Planning Application Ref: LU/11/21/T

Location: Riverside Industrial Estate, Unit G and Unit H Bridge Road, Littlehampton, BN17 5DF

Description of works: Various works to 36no. sycamore trees and 9no. Scots pine trees

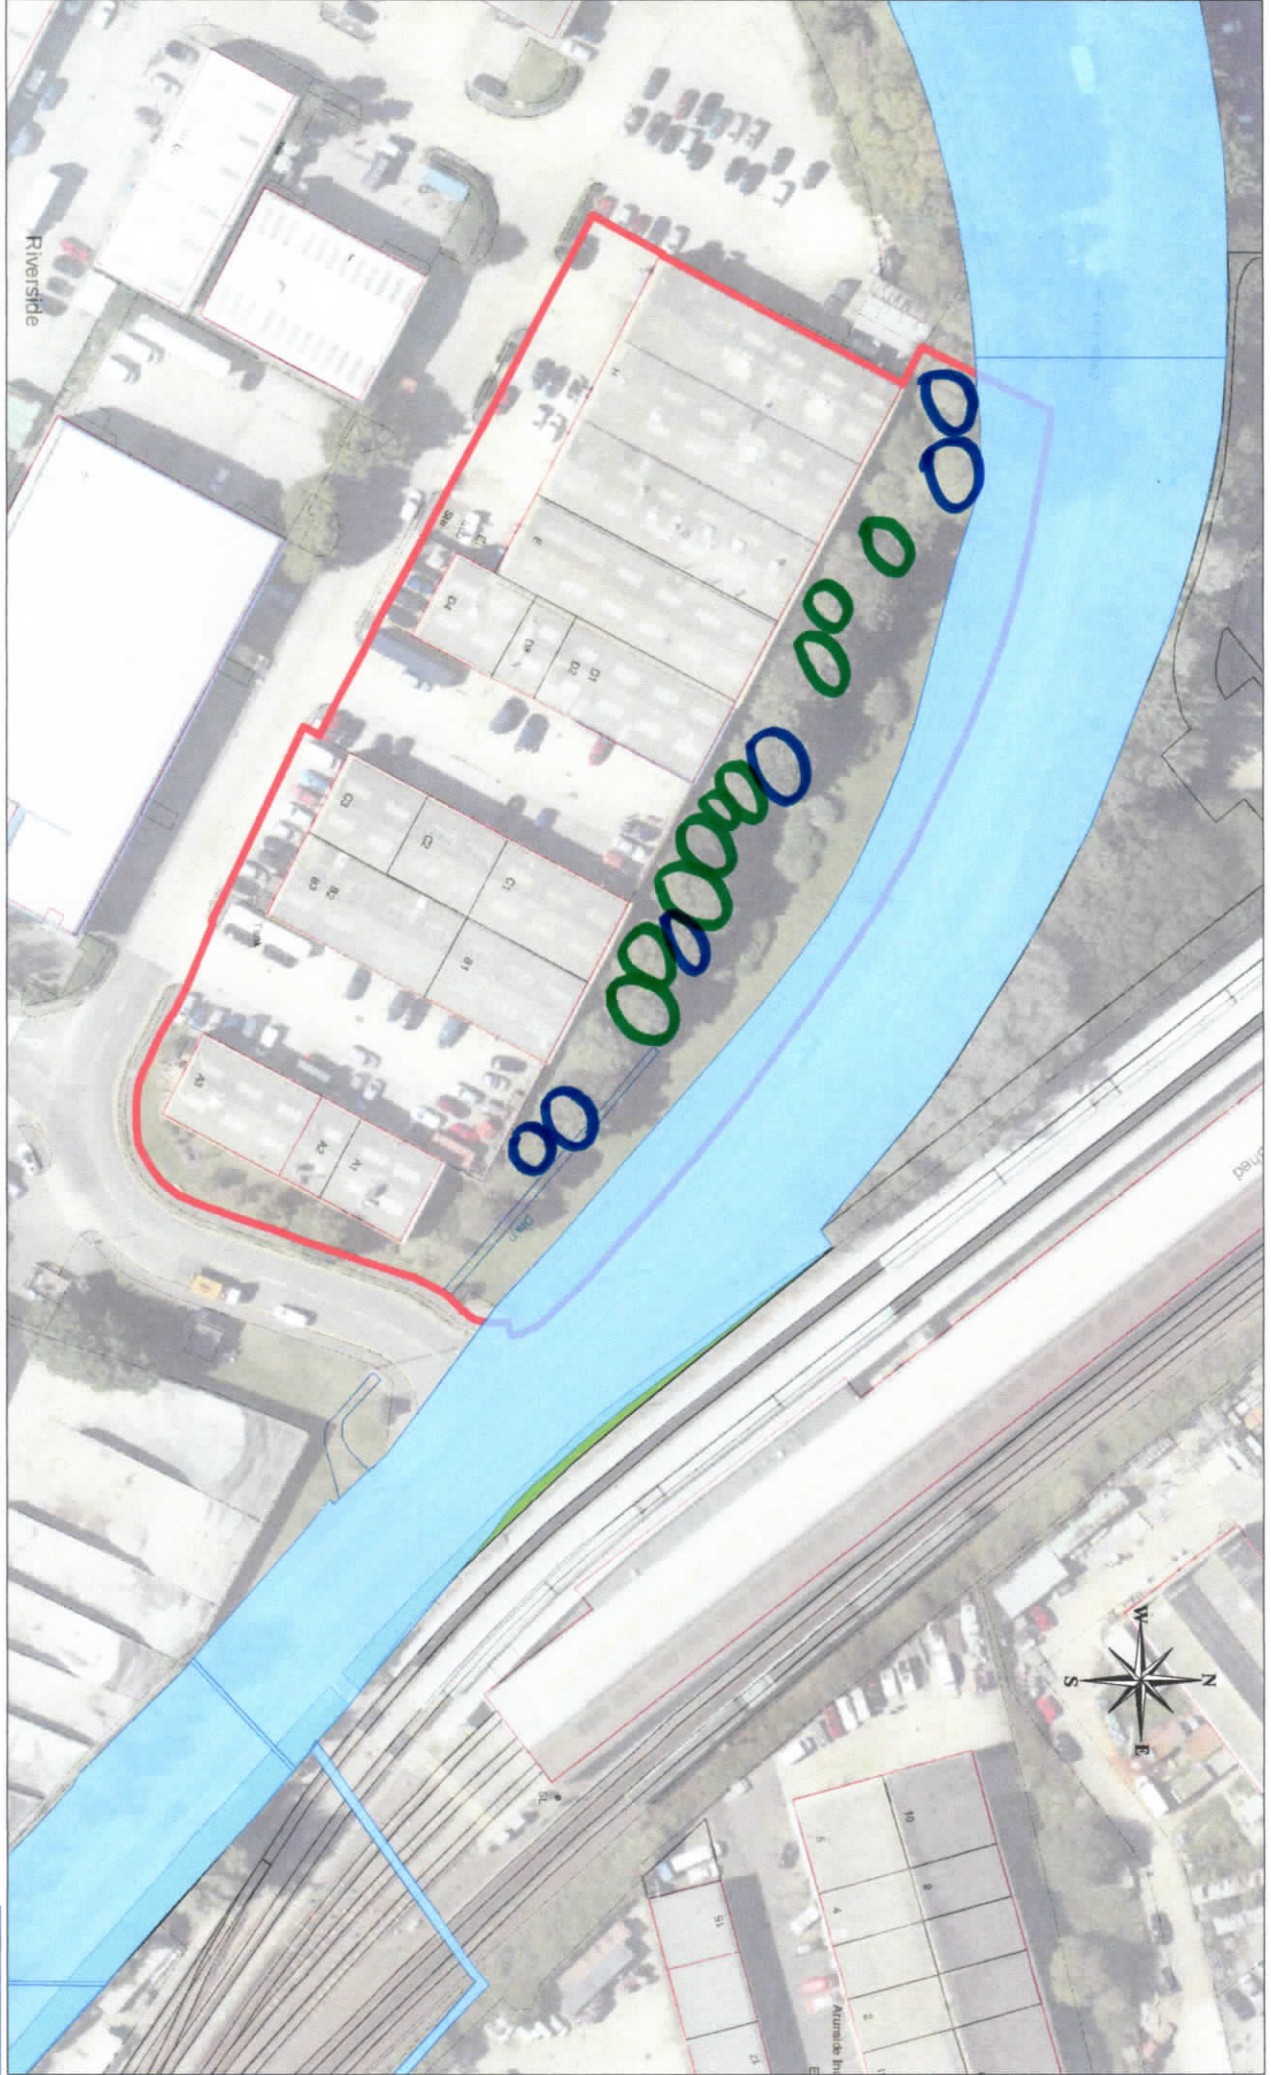
- I accept that some of those trees may not be ideally positioned and/or suppressed by others, requiring some future thinning (selected felling of individuals) for the betterment of the group. The group is a strategically important feature in the landscape and natural crown profiles should be preserved wherever possible. At this time, any existing or near-future building interference can be resolved through selective pruning of individual branches.

- Although proximity of tree roots to building foundations can be a concern, no evidence has been submitted that would implicate any tree in a damage event or suggest it has a foreseeable risk of doing so.

- While it is acknowledged that it may not be reasonable to allow certain trees in the group to achieve their full growth potential; they are trees of public amenity value that can be satisfactorily managed without recourse to such extensive crown reduction work at this time.
- The trees are a significant feature in the local landscape and appear to be in adequately sound and healthy condition. The tree surgery proposed in the application would result in excessive reduction of their landscape impact and undue detriment to the visual amenities of the locality.

- As it stands, I recommend **REFUSAL** for this application.
- **I would like the applicant to be invited to agree to a revised proposal for lesser works** (such as described below) as part of the current application so as not to incur further delay. Such work would go some way to addressing their concerns whilst preventing a diminution of the trees' landscape and public amenity value:
 - *Remove/reduce selected branches to achieve a maximum of 2metres clearance from buildings and fixtures.*

- Part a) Where whole branches are to be removed and final cuts made close to the trunk or branch union they are to be made as shown in Figure 2 of BS3998:2010
- Part b) Where branches are to be shortened back the final cuts are to be made at the correct angle shown in BS3998:2010 and adjacent to a live bud or lateral.
